REVIEW OF ORICA SOUTHLANDS REMEDIATION and DEVELOPMENT

HYDRAULIC MODELLING REPORT and RESPONSE to EXHIBITION SUBMISSIONS/COMMENTS

DEPARTMENT OF PLANNING and INFRASTRUCTURE

AUGUST 2011

Southlands Industrial Estate **Figure D9a**
Final Development Scenario 50% AEP flood level difference map

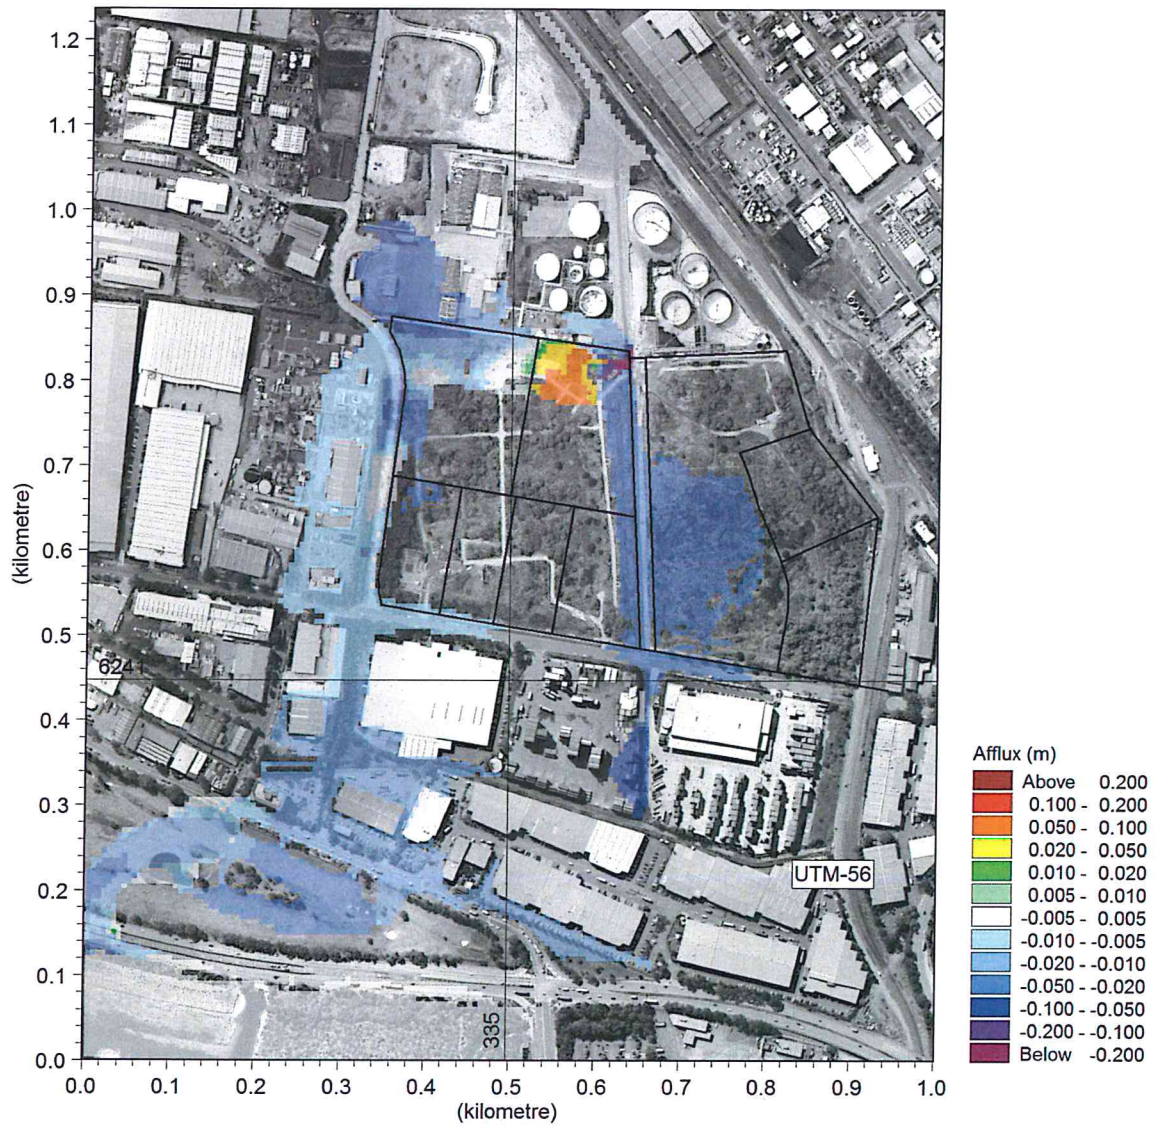
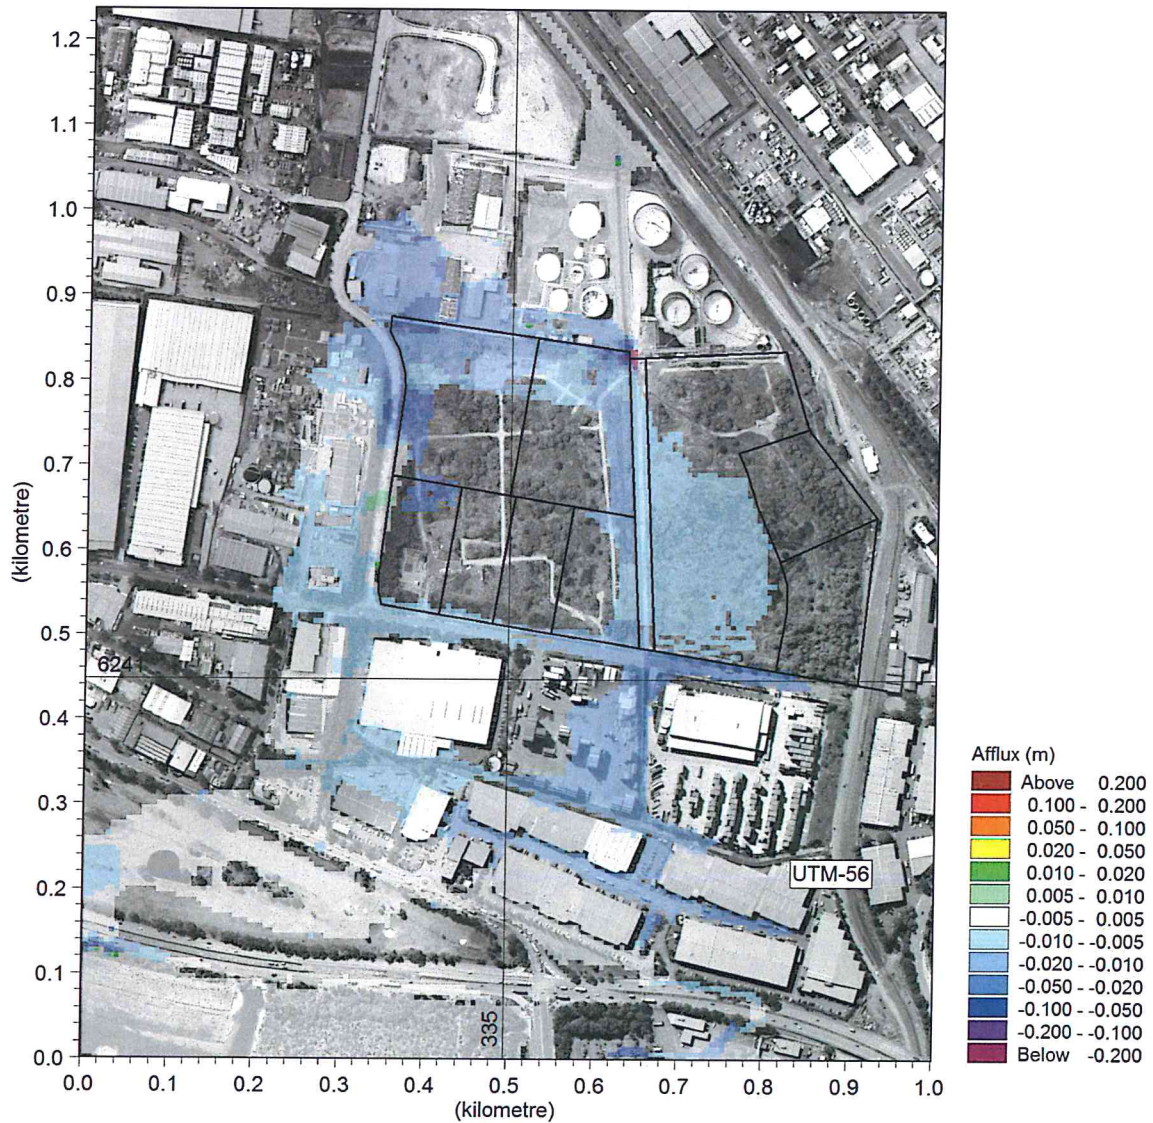
7. The Stage 1 design relies upon a re-distribution of earthworks within the site and construction of a control structure to divert floodwaters into the detention basin. The November 2010 report (*Report Ref: 204617, 29th November 2010, Revision 3 by Aurecon*) acknowledges (page 25) that any change in the design may require re-modelling. The Proponent shall commission and pay the full cost of a Hydraulic Modelling Flood Validation Assessment Report to confirm that the as constructed Stage 1 works (filling and construction of the detention basin) have been undertaken in accordance with the principles outlined in the November 2010 report, and that the flood impact is no greater than indicated in Figures D9, D10 and D11 of that report. The assessment must:

2. provide detail survey from a Registered Surveyor on all key structures;
 3. provide easy to read figures indicating any differences between the results provided on Figures D9, D10 and D11 of the November 2010 report;

- recommend and prioritise measures to be undertaken in the event that the assessment shows that the flood impact exceeds that shown on Figures D9, D10 and D11 of the November 2010 report and that the works as executed are not in accordance with this approval;
